# Cottam Solar Project

## Applicant's Comments on Responses to the Secretary of State's First Request for Information

PINS reference: EN010133  
Document reference: DEC/C8.1.43  
Rule 8(1)(b)

Figure 8.16.5: Landscape and Ecology Mitigation and Enhancement Plan – Cottam 1 South (Sheet 2) Revision A

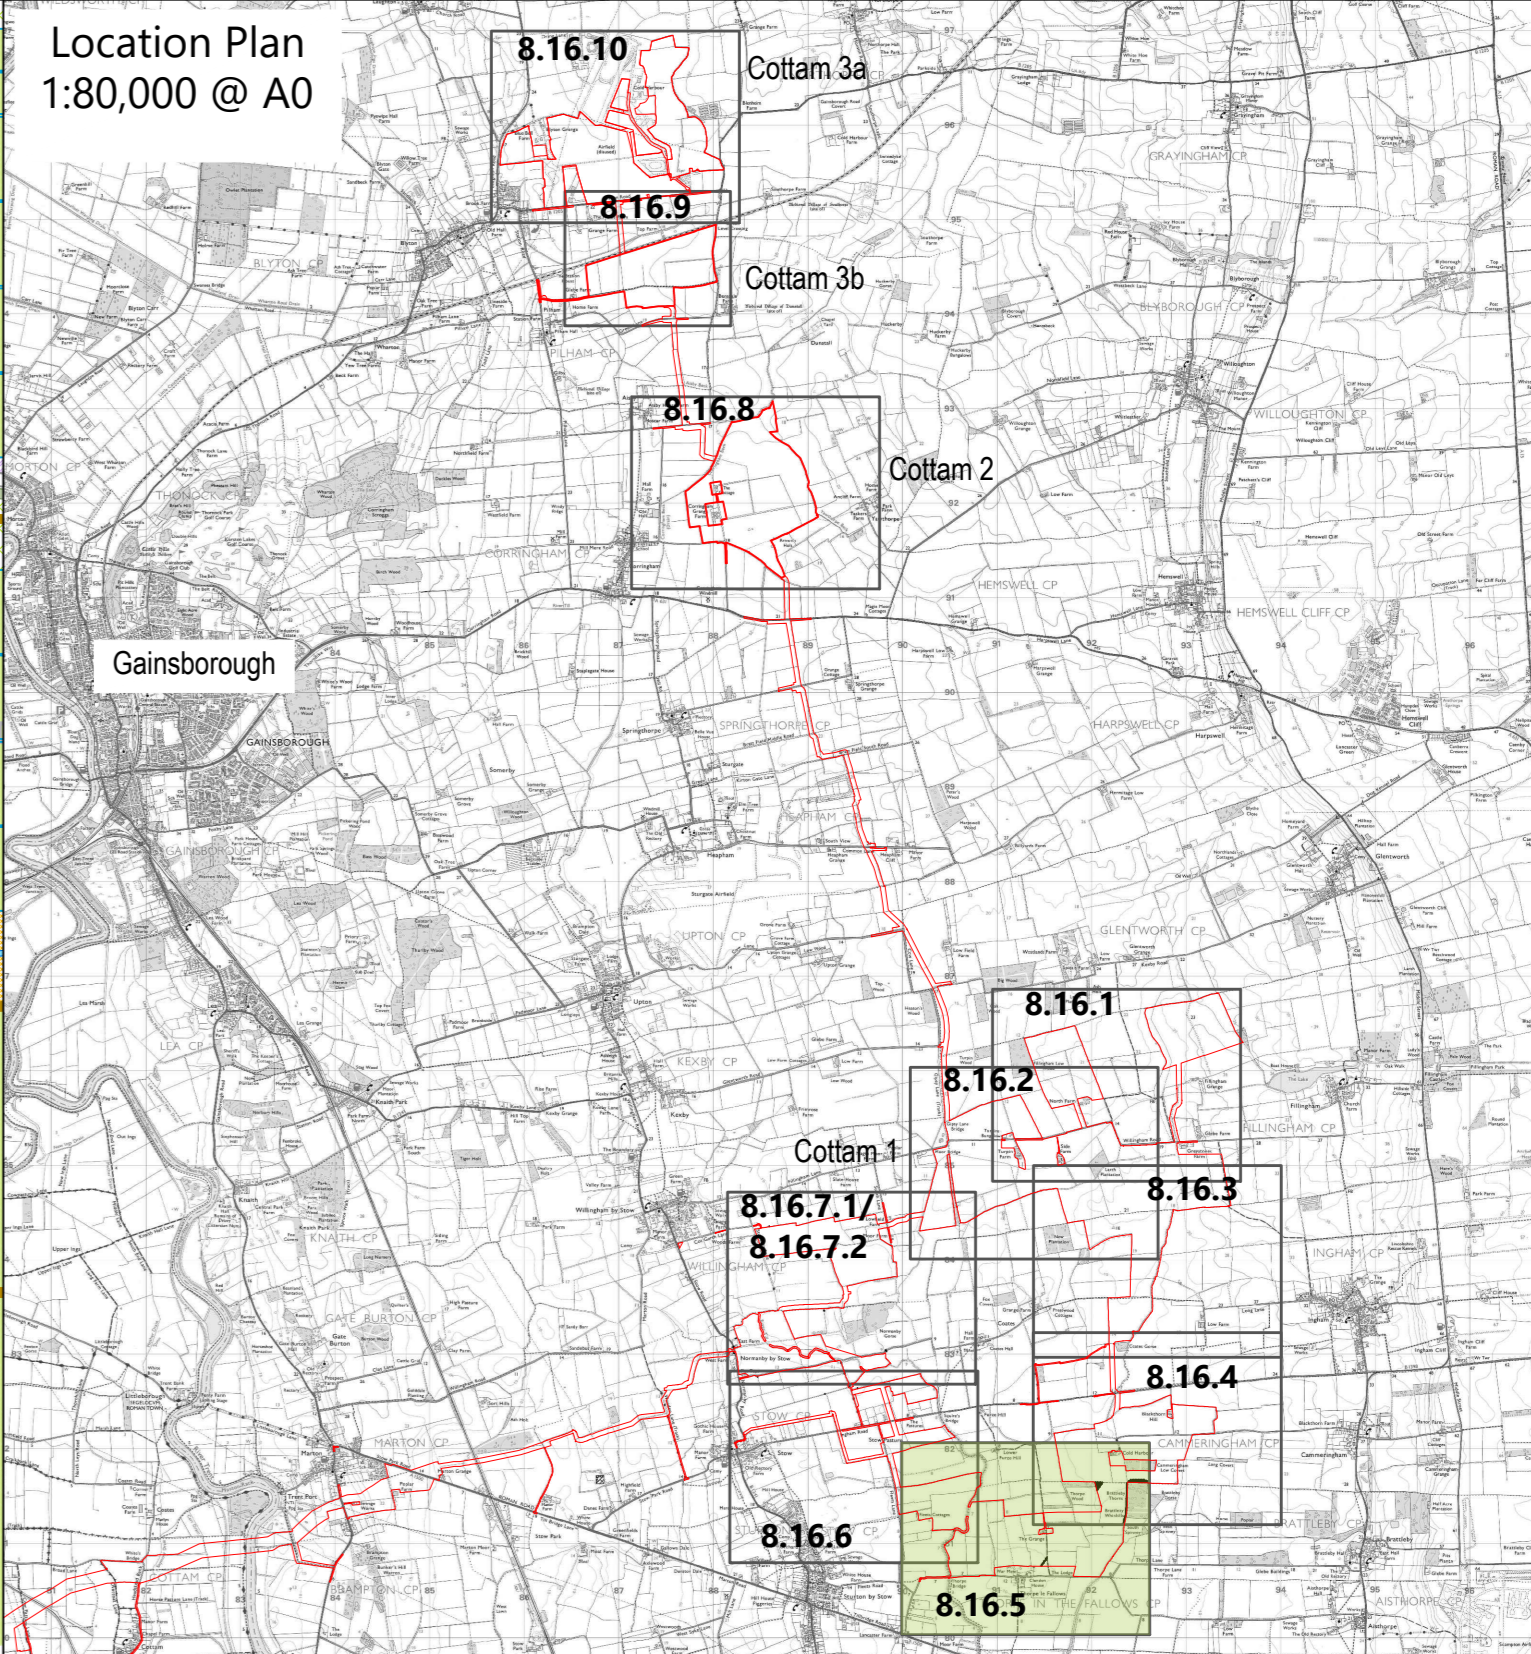
Thorpe in Fallows Scheduled Monument				
16	Historic England	<p><b>The Applicant</b> is requested to revise the design of the Proposed Development to remove solar arrays on land between the Thorpe in Fallows Scheduled Monument (1016978) and the former historic east-west boundary recorded on the 1886 25-inch Ordnance Survey map, approximately along the line of grid points: SK90976 80920, SK91149 80944, SK91330 80904 and SK91351 80909. The former historic east-west boundary must also be reinstated as a hedgerow with the inclusion of appropriate native tree species. <b>Historic England</b> and <b>West Lindsey District Council</b> are invited to confirm if they are content with this request.</p>	<p>We are content with this request and can confirm it addresses our advice and concerns as government's advisor in relation to the setting of the scheduled monument.</p> <p>The applicant has shared with us drawing references Ref: P2981_LPR_ZZ_ON_DR_Z_0064 / Revision D / Sheets 12/20 and 13/20 dated 23/07/2024 which we are content set out the revision as described above.</p>	<p>The drawing referred to by Historic England is the revised sheets 12 and 13 of the Works Plan <b>[DEC/C.2.4_D]</b> submitted with the Applicant's letter dated 6 August 2024 in response to the SoS's first RfI.</p>

16	West Lindsey District Council	As above	<p>WLDC notes the request made to the applicant to revise the design of the Proposed Development to remove solar arrays on land between the Thorpe in Fallows Scheduled Monument (1016978) and the former historic east-west boundary recorded on the 1886 25-inch Ordnance Survey map. WLDC have been invited to confirm if they are content with this request. The position taken by WLDC was that removing solar panels and associated infrastructure back to the historic northern boundary would be required to ensure the impacts upon the Scheduled Monument were acceptable.</p> <p>Upon request, the Applicant has provided WLDC with an updated work plan (Ref: P2981_LPR_ZZ_ON_DR_Z_0064) (dated 23/07/2024) drawing removing solar panels from the area concerned. It is understood that Historic England have also received and reviewed this amended drawing and has confirmed that it addresses their concerns with regard to impacts on the scheduled monument.</p> <p>WLDC welcomes this amendment and agrees with Historic England in that it addresses the principal objections. There</p>	<p>As set out in the Applicant's letter dated 6 August 2024 in response to the SoS's first RfI, the land has been retained within the Order limits as it may be required for underground cabling (Work No. 1A(iv)) and landscape and ecological measures (Work No. 7A). Further details are set out in the revised version of Cottam 1 South Sheet 2 of the Landscape and Ecology Mitigation and Enhancement Plan <b>[DEC/C6.4.8.16.5_B]</b> that was also submitted on 6 August 2024.</p>

<p>are, however, some further clarification that would be helpful in order to fully understand the nature of the proposed changes:</p> <p>It is noted that the amended work plan supplied to WLDC is annotated for Works 1a(iv) (electrical and communications cabling connecting Work No. 1A(iii) to Work No. 4A) and Work No. 7A (variety of works including fencing/boundary treatments, security and lighting, landscaping and biodiversity mitigation, maintenance of existing and creation of new internal access tracks, footpath diversions, earthworks, sustainable drainage system ponds and general drainage, acoustic barriers, electricity and telecommunications connections and temporary construction/ decommissioning laydown areas).</p> <p>In the absence of an updated indicative site layout plan, it is not clear what development is likely still to be proposed in the area where solar panels have been removed. Such works would include earthworks and fencing. WLDC would welcome clarification of why these works appear to still be retained to be</p>

<p>authorised within the defined area of particular sensitivity with regard to the setting of the Scheduled Monument.</p> <p>Work No. 7A provides for a wide range of development that isn't as yet defined and WLDC would be grateful for clarity to ensure that the impacts on the setting of the Scheduled Monument are clear.</p> <p>WLDC would also welcome confirmation as to what other application documents will be updated to reflect the amendment, particularly those documents to be 'Certified' and form the basis of DCO 'requirements' (e.g. the Outline LEMP).</p> <p>Should the amended documents be submitted, WLC formally requests the opportunity to consider and review the submissions and thereafter provide a further response in writing. WLDC request that clear timescales for the submissions are provided, such that sufficient time is afforded for all Interested Parties to adequately consider the information and provide a full written response thereafter.</p>
